## **Detailed Submission - New High School at Jerrabomberra (SSD-24461956) Objection to Proposal**

# **Submission and Comments from Council on Jerrabomberra High School - SSD-24461956**

Council's Ref: PR.2021.1044  
DPIE Ref: SSD-24461956  
Council Contact: M J Thompson  
[Council@qprc.nsw.gov.au](mailto:Council@qprc.nsw.gov.au)

Drawing No.
JHS-CE-2006
Revision
G

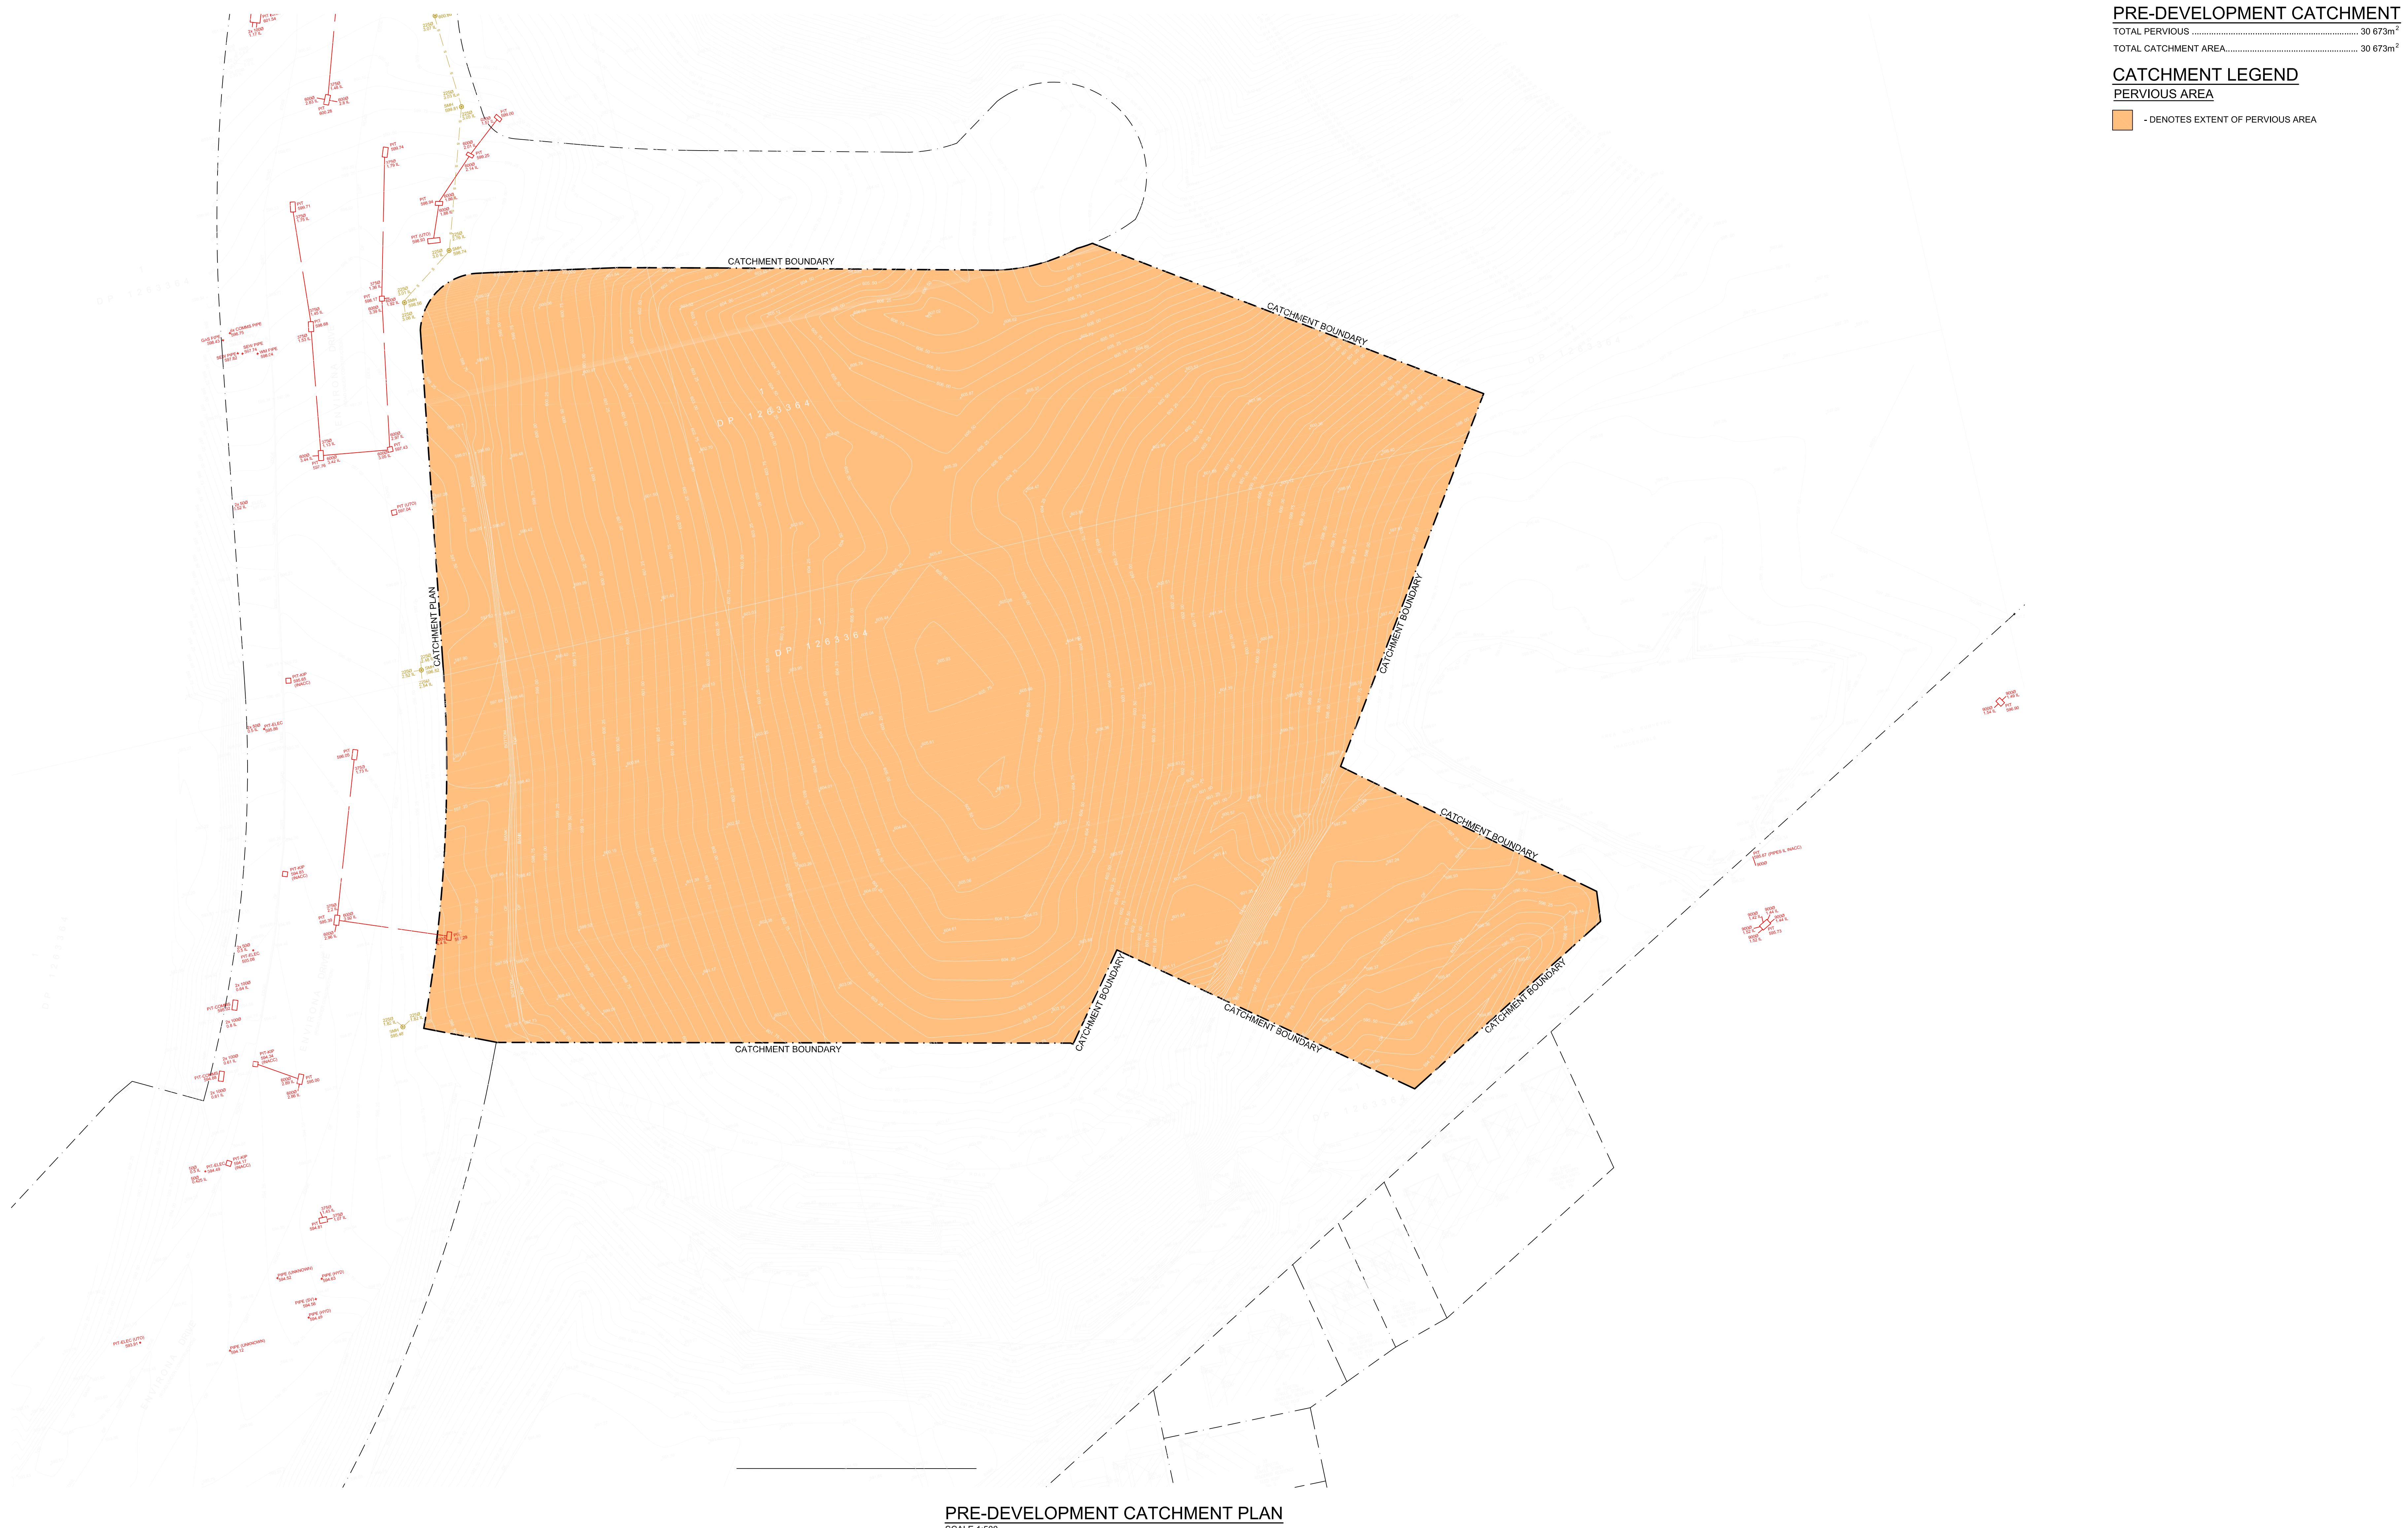
The proposed development of the site will increase runoff, thus a stormwater management plan demonstrating the proposed development will not exceed pre-development runoff flow for both 20% and 1% storm events is required in accordance with Council's D5 Stormwater Drainage Design specification, and water quality in accordance with Council's D7 Erosion Control and Stormwater Management Design specification and corresponding computer modelling.

- Preparation of a hydraulic design plan providing details of the required sizing for all water, sewer and stormwater services required for the site.
- The preparation of an on site detention design to limit stormwater discharge from the site to pre-development flows.
- That all connections and alterations to Council's utility services are inspected by Council staff prior to backfilling.

Project
 High School in Jerrabomberra
 ENVIRONA DRIVE,
 JERRABOMBERRA NSW 2619
 Drawing Title
 STORMWATER DRAINAGE
 PLAN - SHEET 1

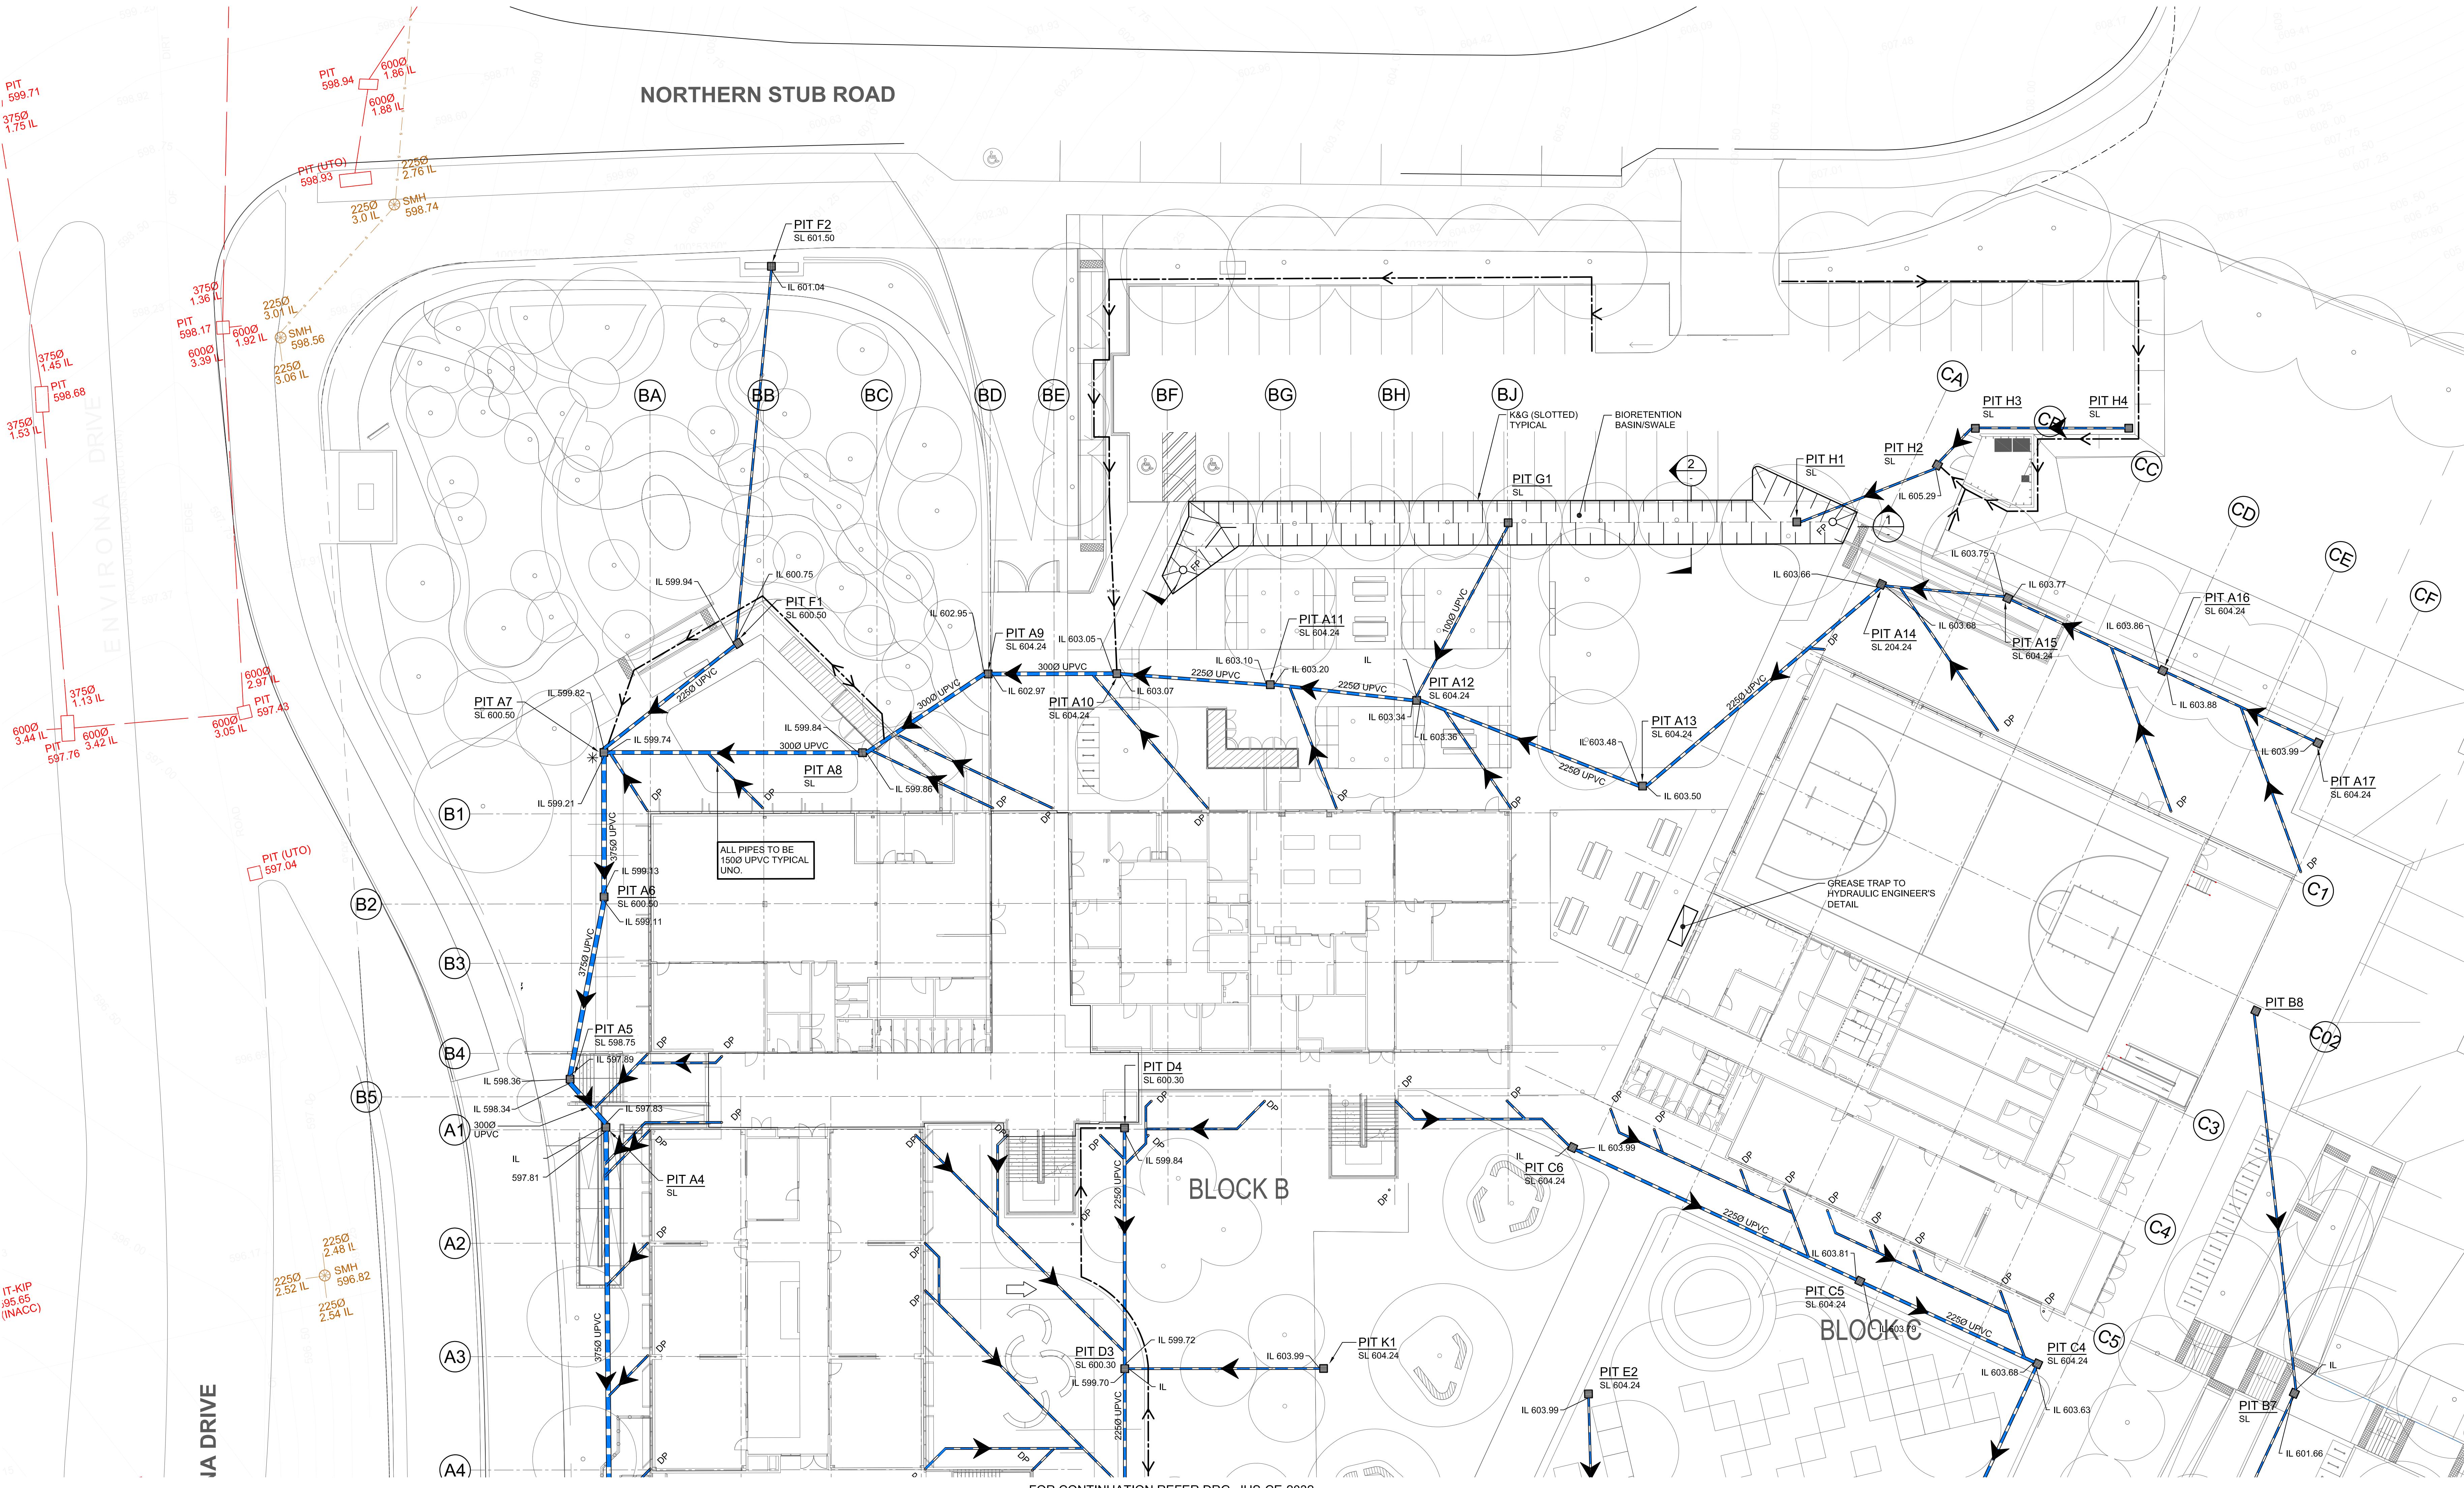
Figure 4 in the plan shows sewer connection to manhole S112 near the Bus Zone. The sewer connection should be through a standard connection to the sewer main running towards the rear of the school block.

The high school development site can be serviced by a storm water connection to the recently constructed pit (G02) adjacent to the Bus Lane with a 600mmØ RCP drainage pipe connecting to the new infrastructure line in Environa Drive.

The provided civil plans support the construction of an on-site detention (OSD) tank to accept stormwater from impermeable areas, which is a necessary requirement for this development.
